Recommendation Report for Planning Permission**REF NO:** EP/149/14/PL**LOCATION:** 37 Orchard Road
East Preston**PROPOSAL:** Construction of 3 bedroom dwelling with rooms in roof space. Resubmission of EP/100/12**SITE AND SURROUNDINGS**

Proposed Street Elevation

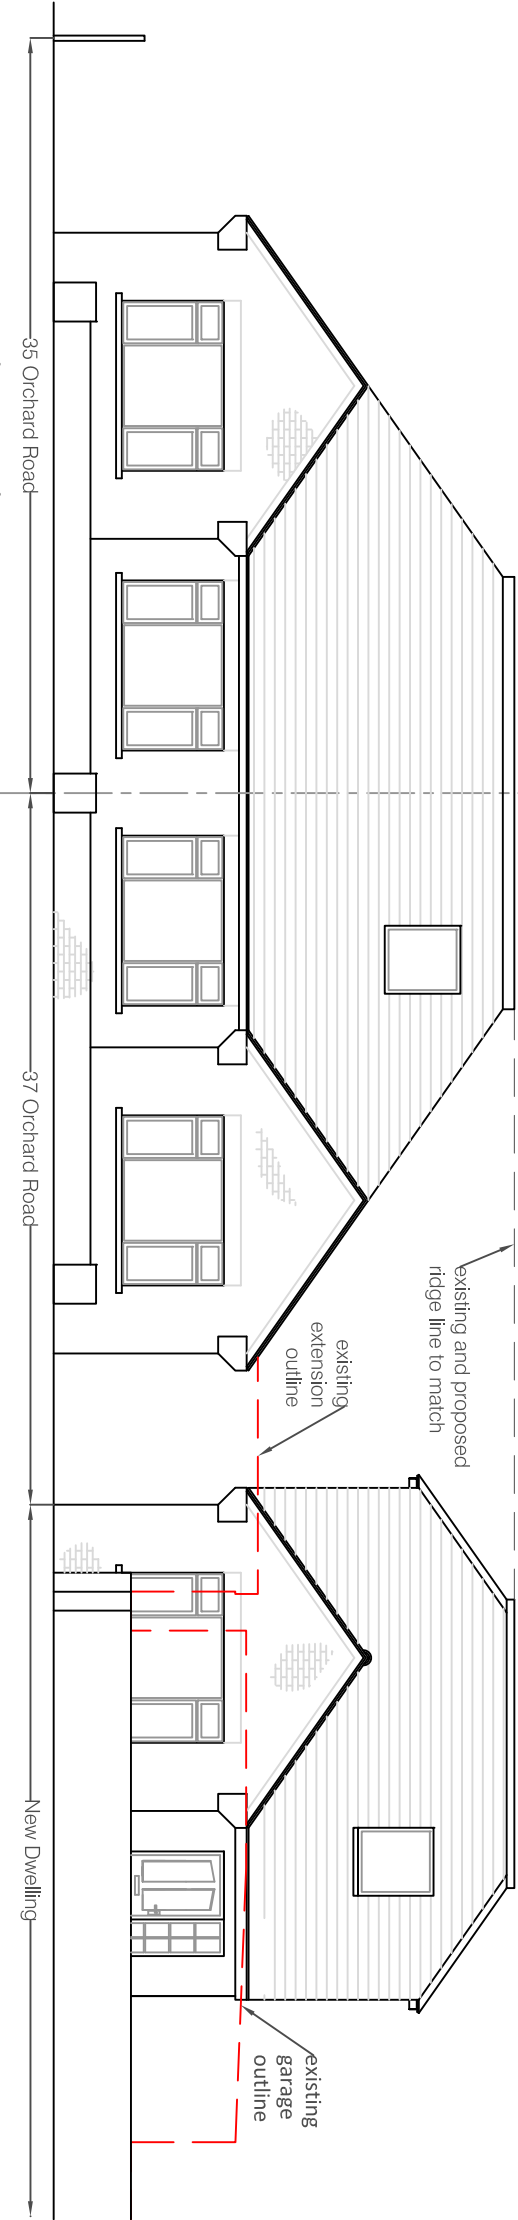
This part of Orchard Road is generally defined by low profile semi-detached bungalows and the proposed detached 2 storey dwelling with a significant depth of the roof to the rear represents an alien and dominant form of development. The height does not exceed its neighbours, but is significant in its width and rearward projection, particularly when considered in relation to the smaller site proportions and its limited width. In addition, the set back position of the dwelling on the site would be out of keeping with the regular and defined relationship of existing properties with the site frontage. This would contribute to its alien and cramped appearance.

The existing paired dwellings have space to their alternate boundaries which contributes to the spacious character of this part of Orchard Road. The proposed dwelling would have no space to its eastern boundary and limited space to the western boundary which further detracts from the character of the area.

- 1 Given the height, width, design and proximity to the boundary the proposed dwelling appear cramped and out of keeping in the street scene adversely affecting the visual amenities and character of the locality in conflict with policy GEN7 of Arun District Local Plan.

Front Elevation (north)

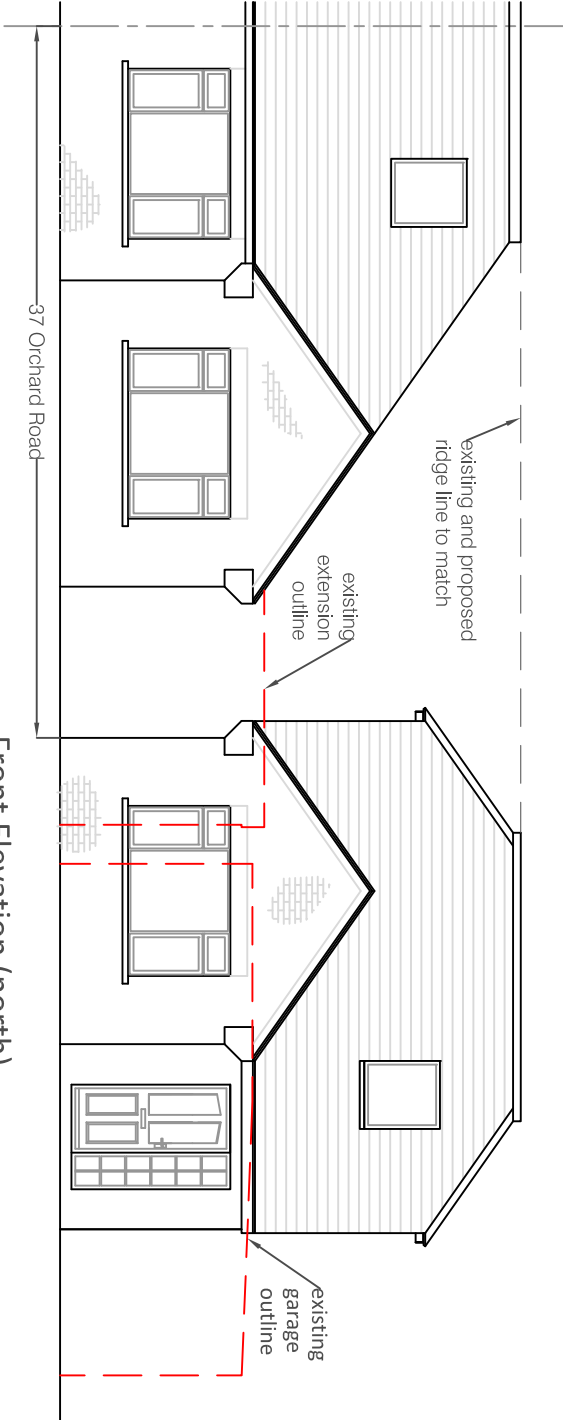
Site is too narrow. Building is poorly proportioned, being too narrow in relation to its height and quite different from the proportions of its neighbour to the west. It also presents a facade that is dominated by the front slope of its roof. Its design is contrary to policy DSP1 of the Emerging Local Plan and policy GEN7 of the Local Plan. The windows of the 2 bedrooms upstairs would overlook the rear of the properties in Windlesham Gardens to the south and Orchard Road to the west, reducing privacy. Parking one behind the other is liable to lead to an increase in on road parking contrary to the emerging Neighbourhood plan.

The dwelling at appeal was the same height as the existing dwelling and this is the height now proposed. The Inspector concluded that the roof form would appear large in comparison and at odds with the simple main roof design of other bungalows. Visual interest was lacking to the front elevation. The application dwelling has addressed visual interest concerns by adding a front gabled projection which replicates a design feature in the street scene. Dormers which were considered to add to the mass of the roof have been removed from the proposal. However, the design of the dwelling is at odds with other properties in the locality, a barn end style roof is now proposed which is not in keeping with other development in the locality and appears bulky and out of place contrary to the character and appearance of the area.

Side Elevation (west)

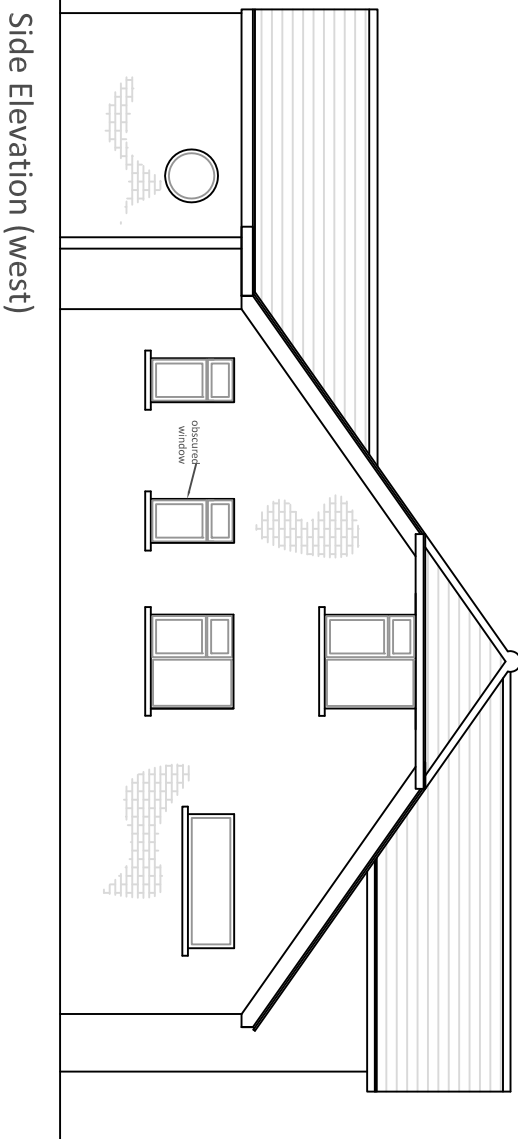
Whilst the proposed dwelling would be close to the side boundary with the area of open space it would not immediately abut any private amenity area and would therefore have no materially adverse effect on residential amenity by way of overbearing effects. The bedroom window on the west side elevation would be 7 metres from the boundary with the garden area serving the adjoining bungalow and would result in adverse overlooking effects. Whilst this window is not indicated to be obscure glazed a condition could be imposed to that effect so as to overcome any unacceptable overlooking. The distance of 11.7 metres from the first floor window to the boundary with dwellings in Windlesham Gardens to the rear is adequate to prevent any material loss of privacy.
